Your Ref: OWPC3310
Our Ref: BR/170/14/PL 10-07-2014
Please ask for:
Mr C Cronin

Erection of a temporary marquee for use as an additional summer entertainment venue
between the months of June to September for a period of 5 years

Butlins Upper Bognor Road Bognor Regis

Site Layout Plan

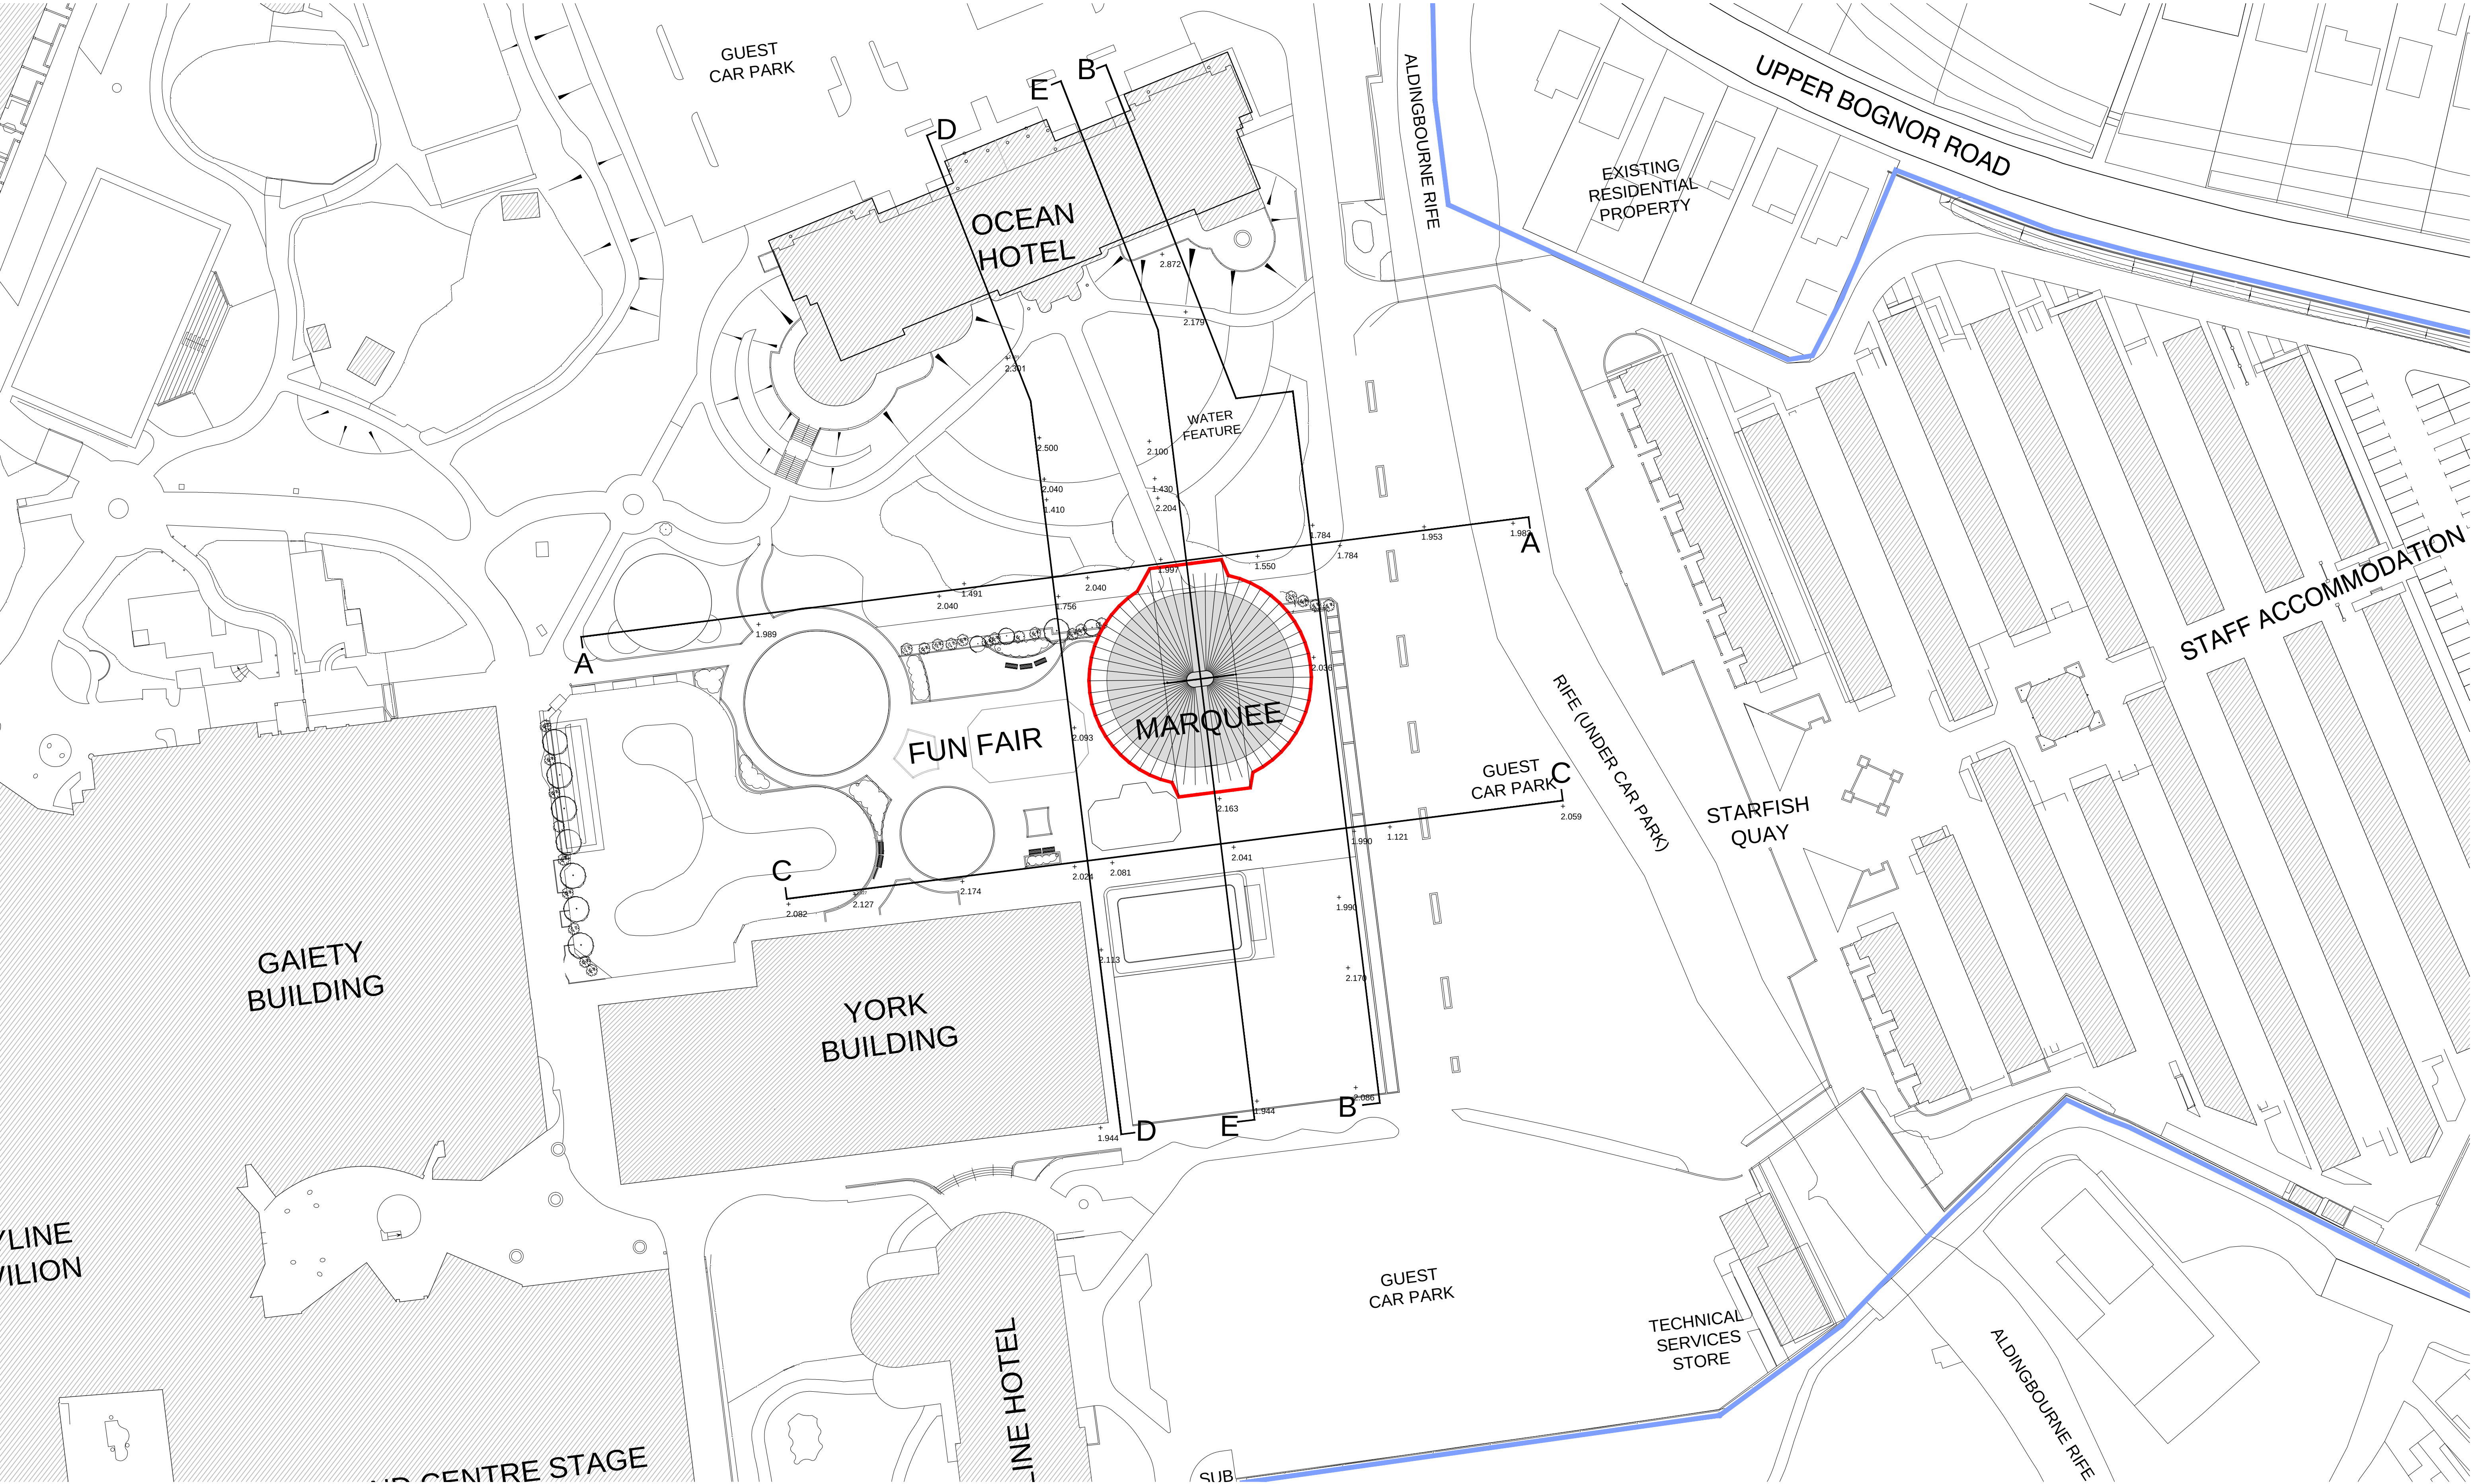
The centre of the Marquee is stated to be 78 metres from the camp boundary, we live 20 metres from the boundary which means we are within 100 metres of the performances with only a canvas layer with openings in between us. There are no other buildings to protect us from the noise. Also should the measurement not be taken from the edge of the Marquee?
